23 January 2021

EN020022: AQUIND Interconnector. Examining Authority's further written questions
Reference: TT2.16.7

TITLE:
**Figure 24.2
Illustrative cable route, HDD sites and
joint bays for noise and vibration assessment
Sheet 1 of 15**

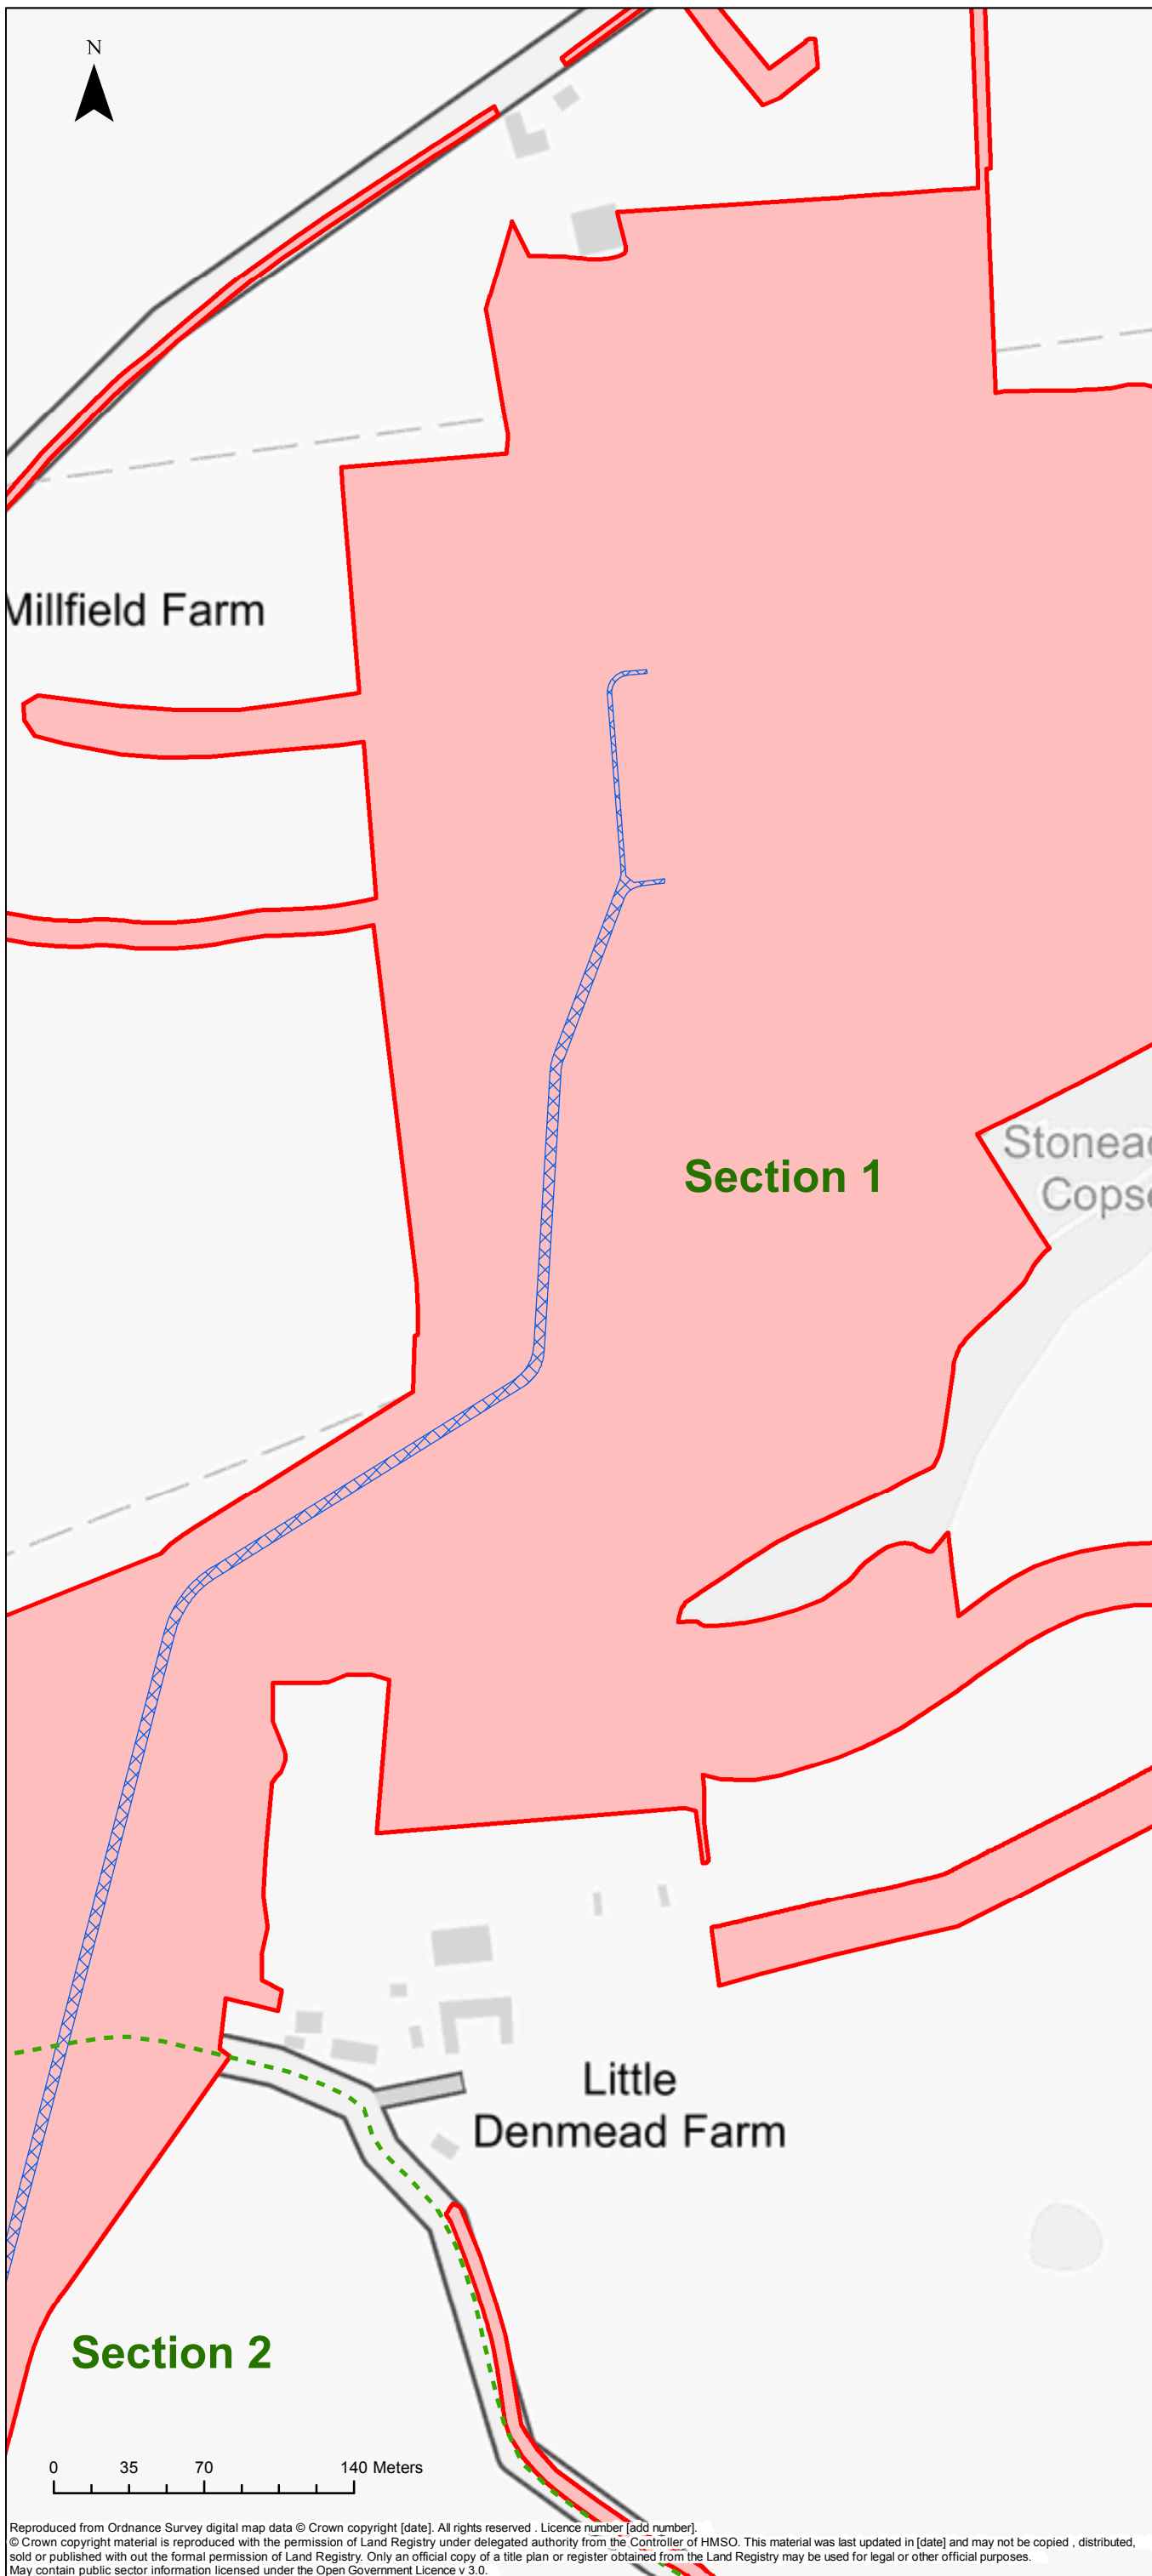
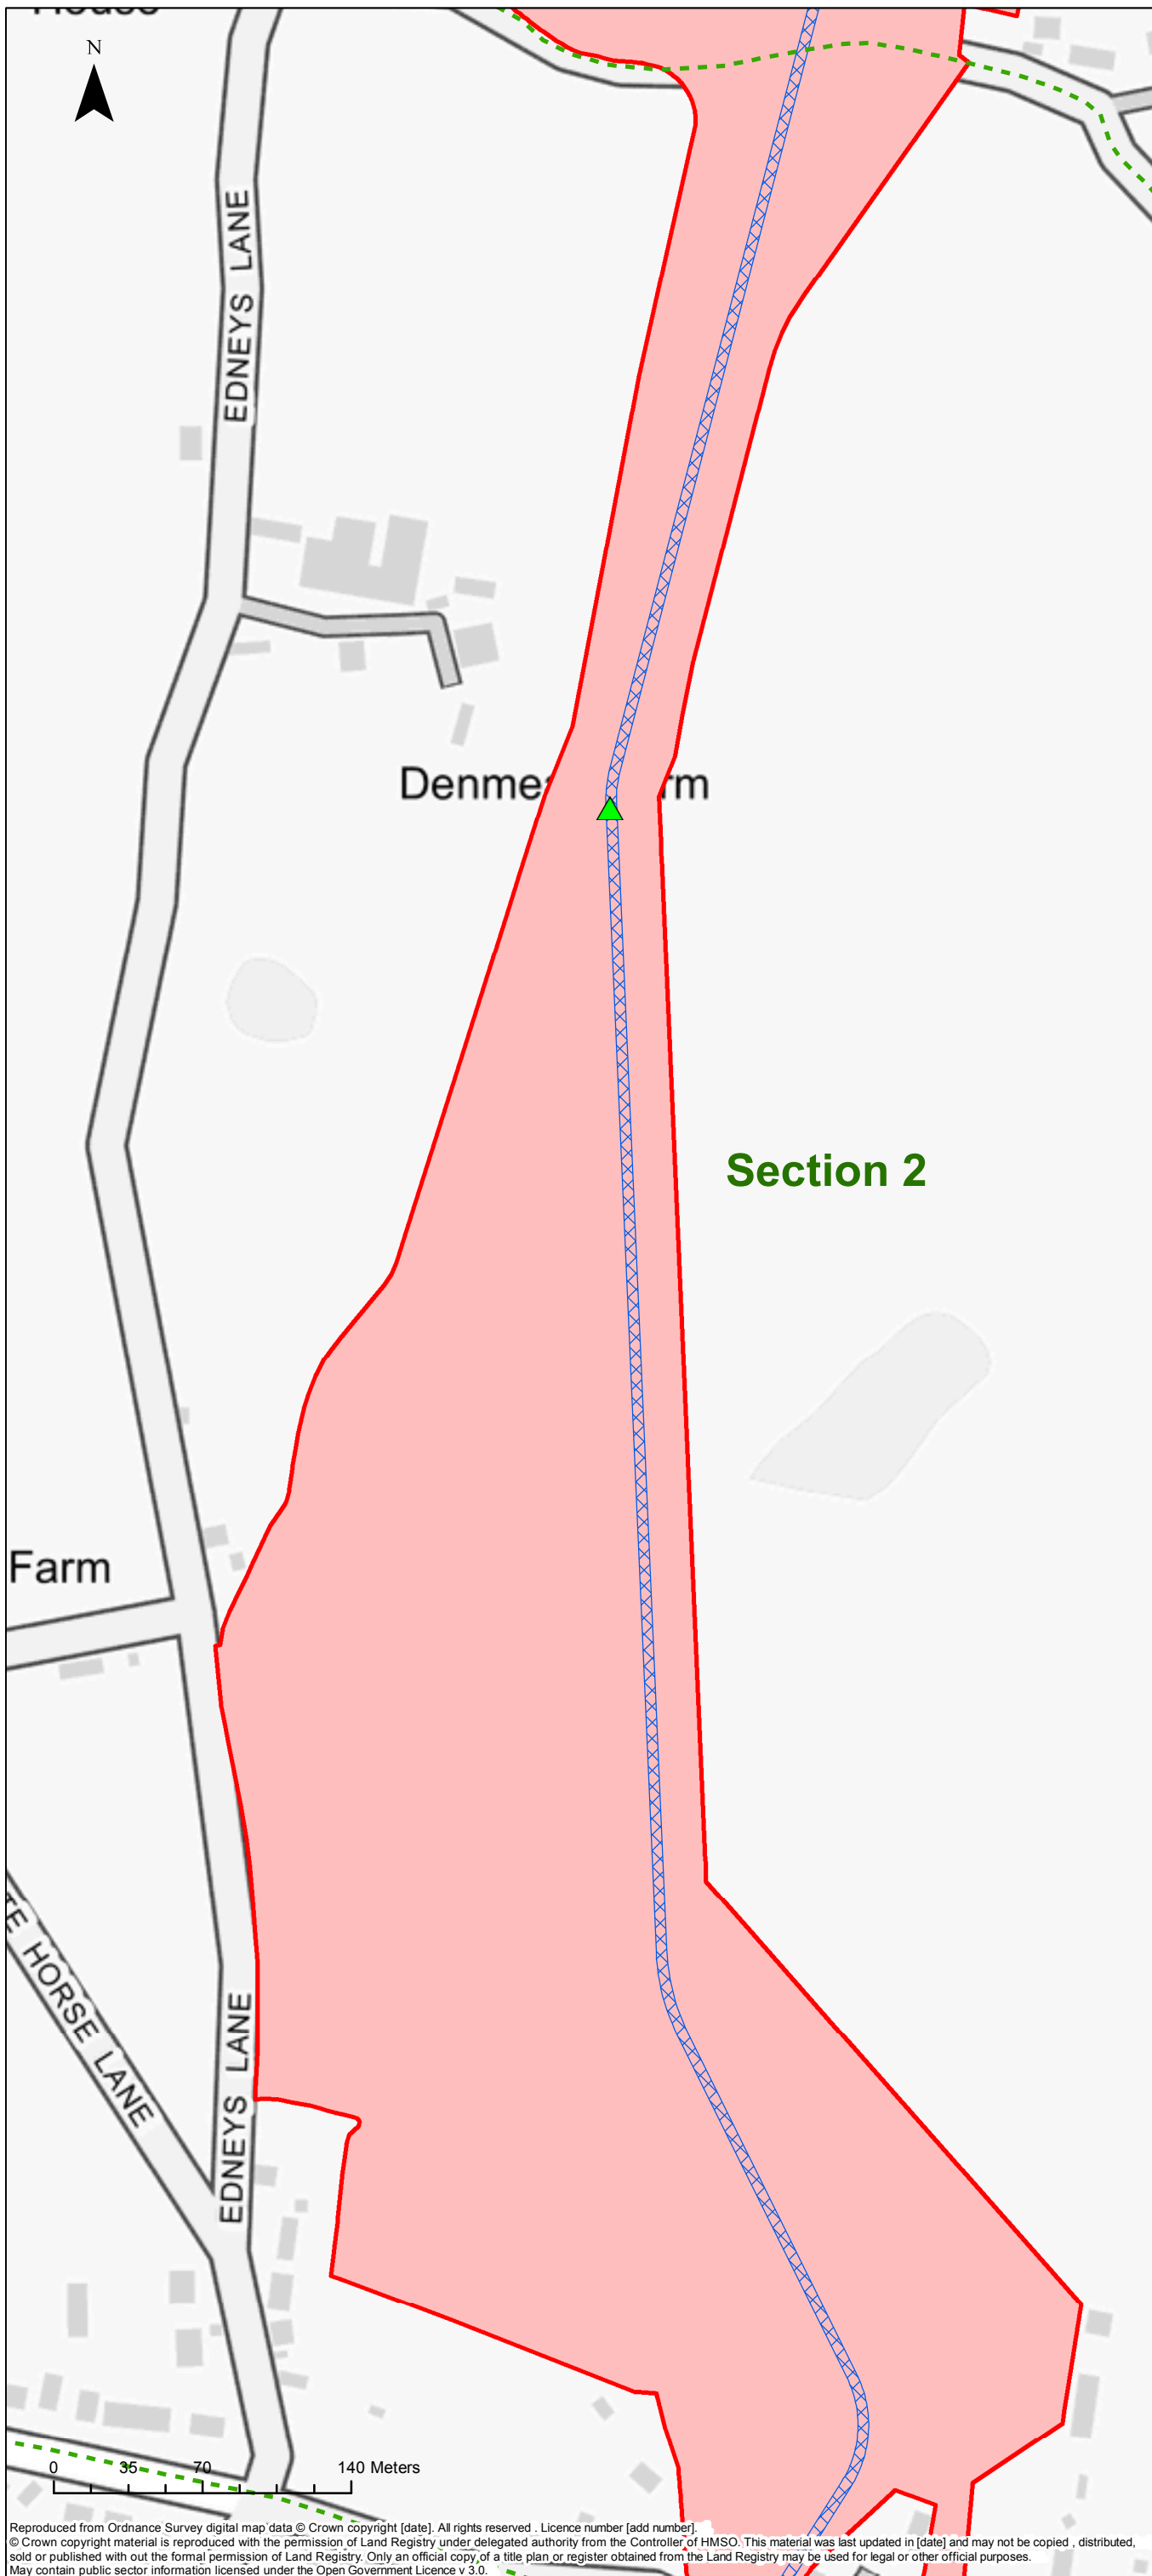
Specifically, this related to JB01 (as detailed in the Joint Bay Technical Note REP6-070 issued on 31 December 2020) and cable drum delivery route provided. While we acknowledge the location of the joint bays are indicative and there are more shown than is permissible in the dDCO, JB01 cable drum delivery route is incomplete, only providing information as to how the Cable Drum will be delivered to Day Lane by following the construction traffic route from the A3(M) to the Converter Station, but importantly not from the Converter Station to the designated location for JB01.

As detailed in point 3.4.2.2 in the Construction Traffic Management Plan (Doc. Ref. 6.3.22.2), construction traffic is not allowed to make use of Broadway Lane to the south, beyond the haul road. The query has not yet been raised by the Examining Authority, but it should request the Applicant provide further detail as to how it intends to manoeuvre the cable drum (detailed as an Abnormal Load in point 2.8.7.1 in the Construction Traffic Management Plan - Doc. Ref. 6.3.22.2) to the designated location for JB01.
